DEVELOPMENT REVIEW BOARD
SUPPLEMENTAL SUBMITTAL

PROJECT NO. PR-2021-005864
Application No. SD-2021-00212

SUBMITTAL DESCRIPTION: Preliminary Plat revised to show easement 9 adjusted within drive aisle. Infrastructure

Re: Preliminary Plat Review for Proposed Subdivision of Tract 12 of Avalon Subdivision, Unit 5

This Sheet Shows
Existing Easements,
and Easement 9

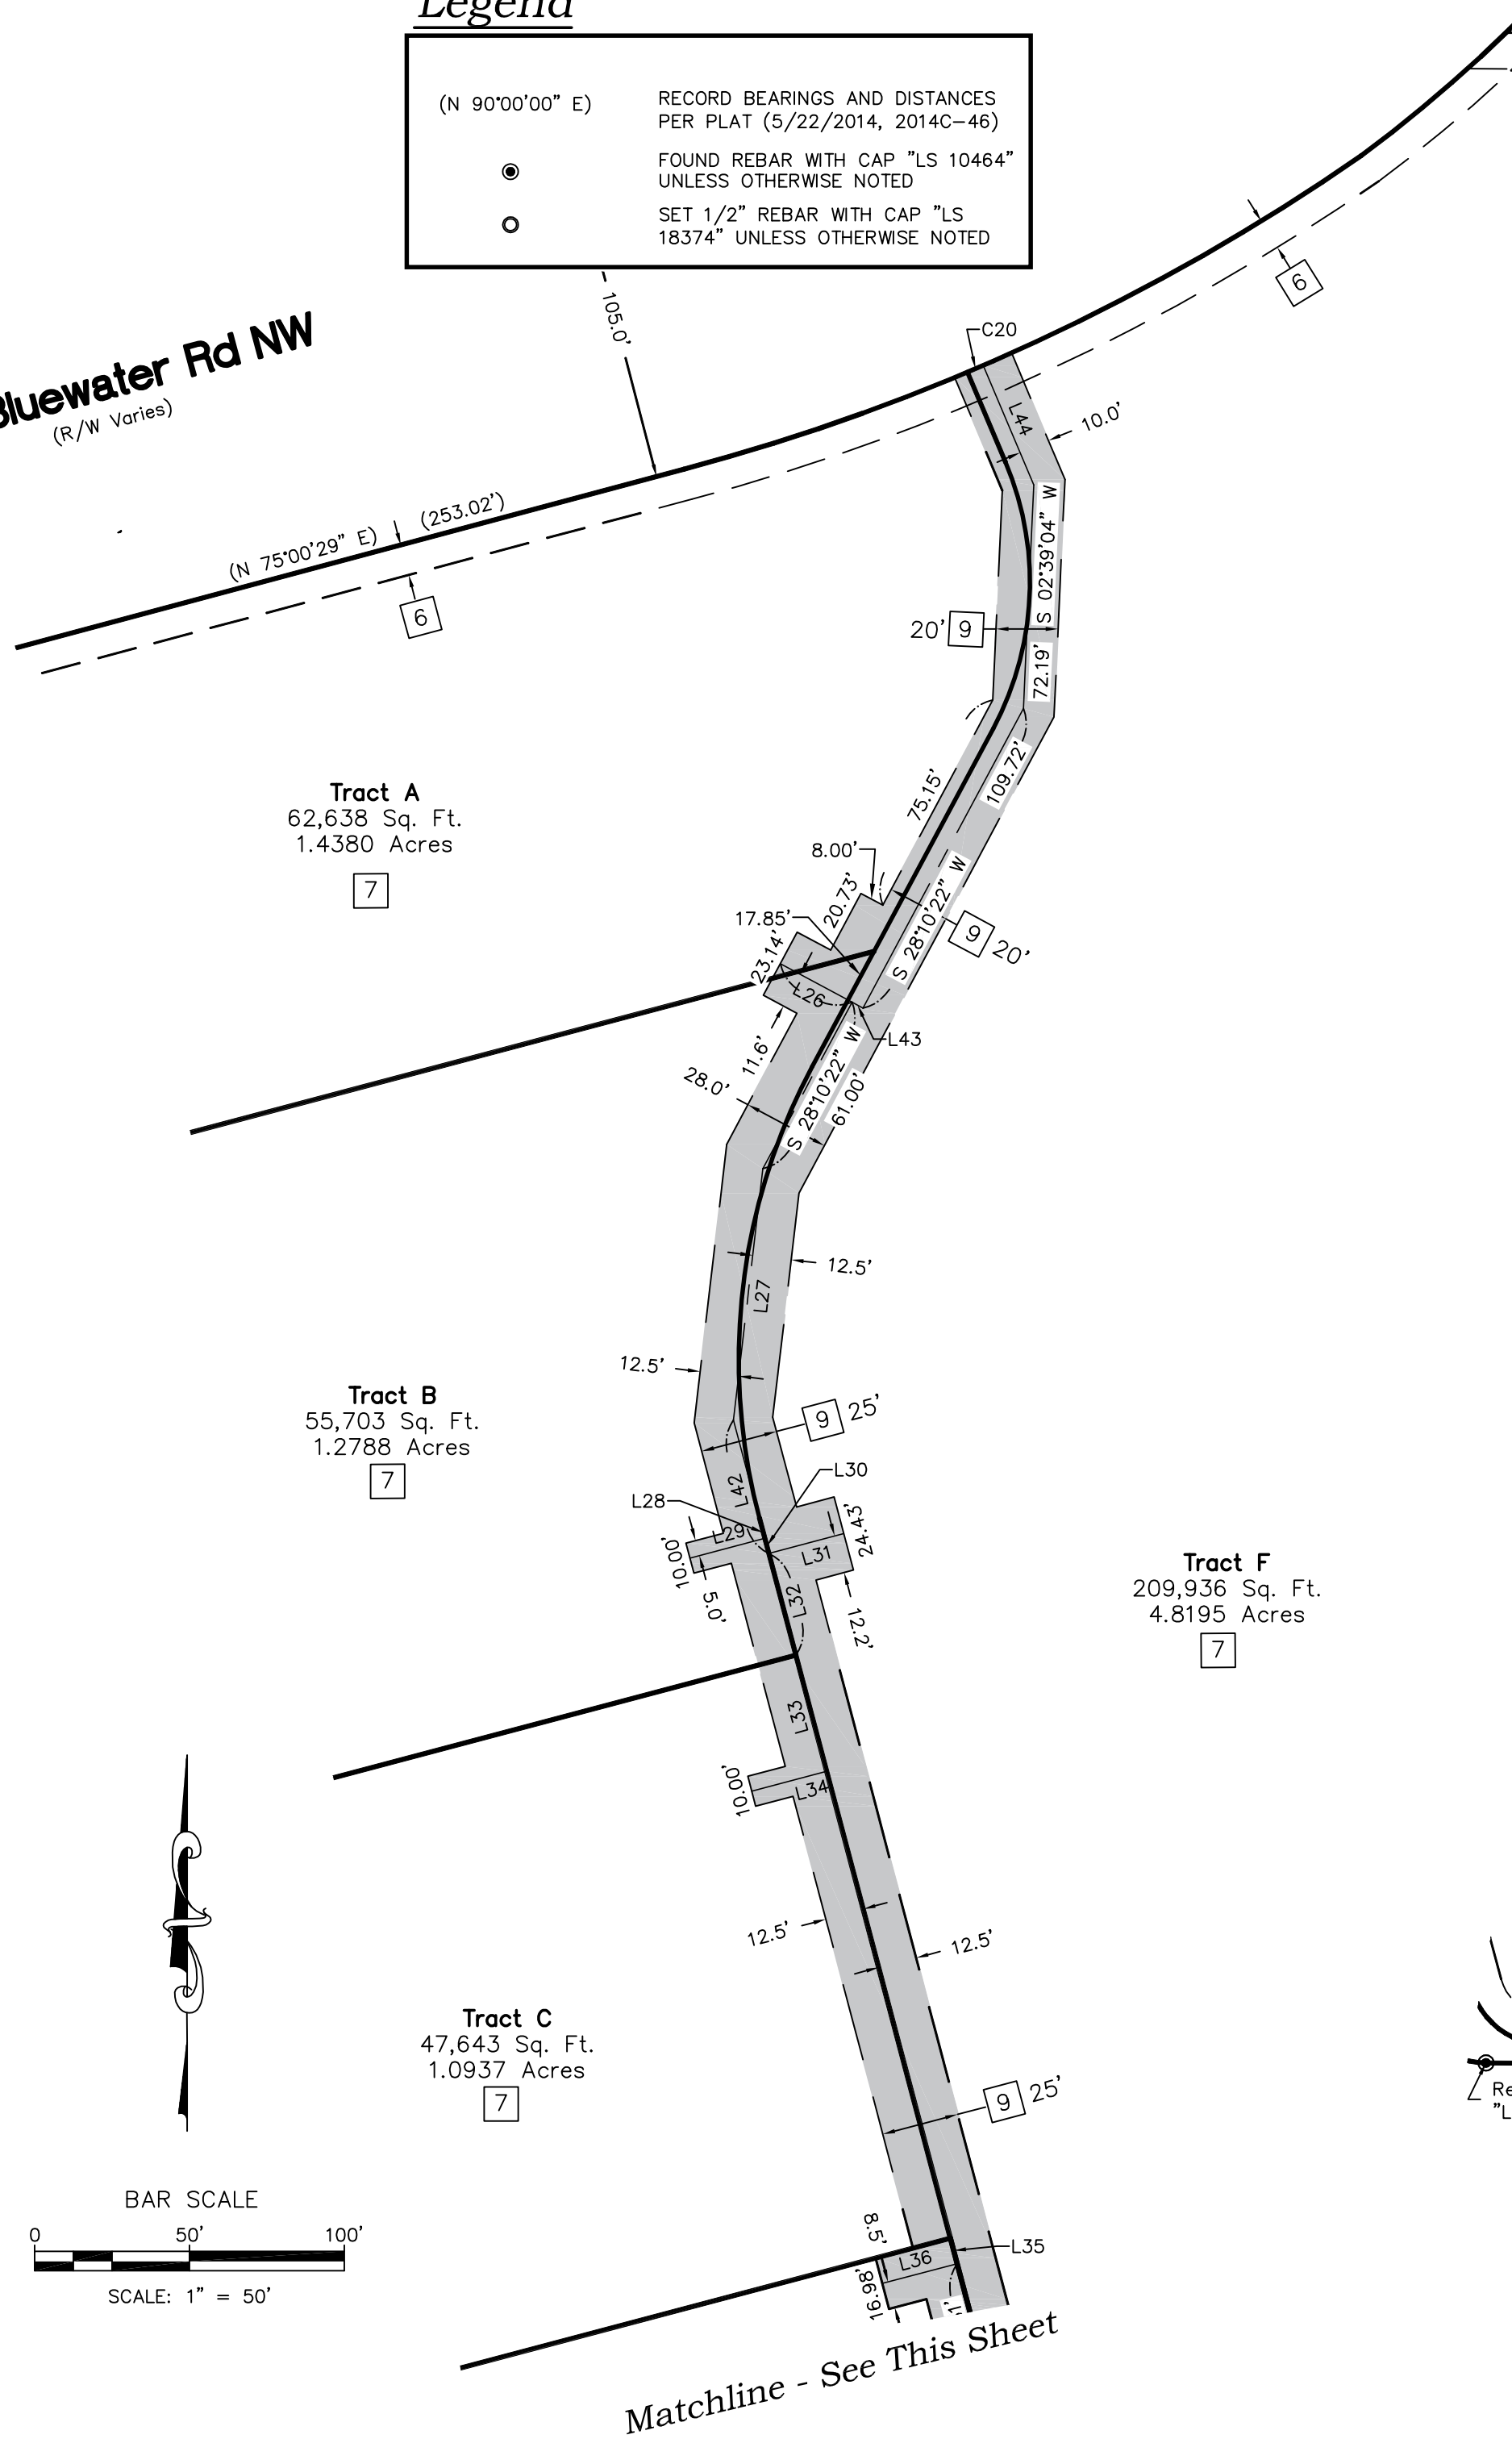
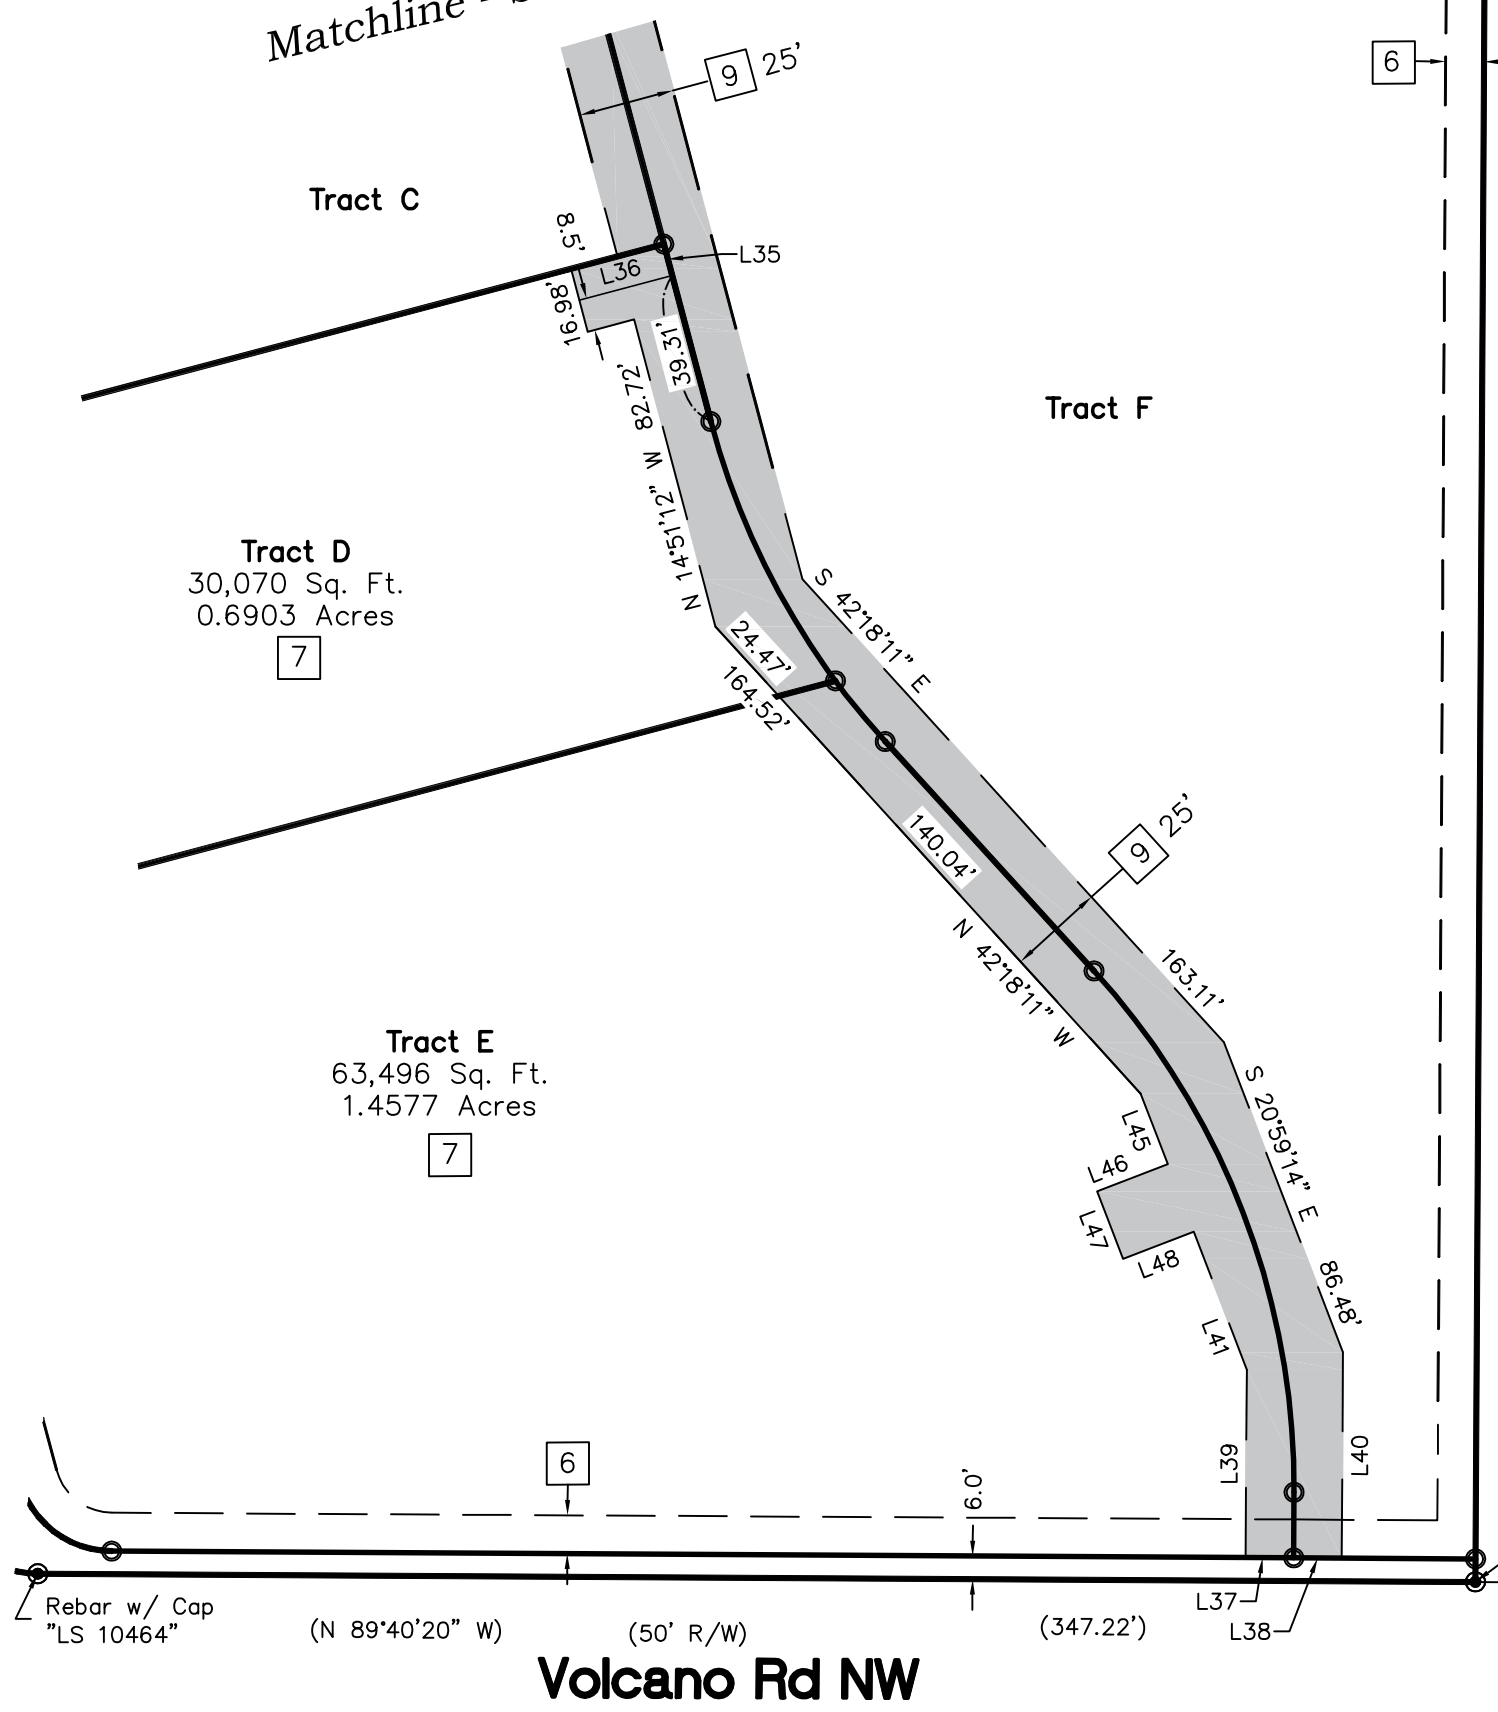
4. Utility Plan:
 - a. The proposed mains and easements need to be under the access road asphalt. The locations where the road bends away from the straight pipe segments are required to be revised to follow the roadway. Also applies to northern water main connection. This final segment of sewer main is also likely to prevent site layouts.
 - i. Public water and sanitary sewer easements shall be modified accordingly. These easements should follow the alignment of proposed easement #8.
 - b. There shall be no trees, parallel fences/sidewalks/curbs, or structures within the public water and public sewer easement. Please revise accordingly.

Noted, easement [9] has been adjusted to lie within the easement [8] access easement and should be clear of improvements or vegetation that would provide an obstacle. Site plan should show no improvements or vegetation unnecessarily crossing these easements.
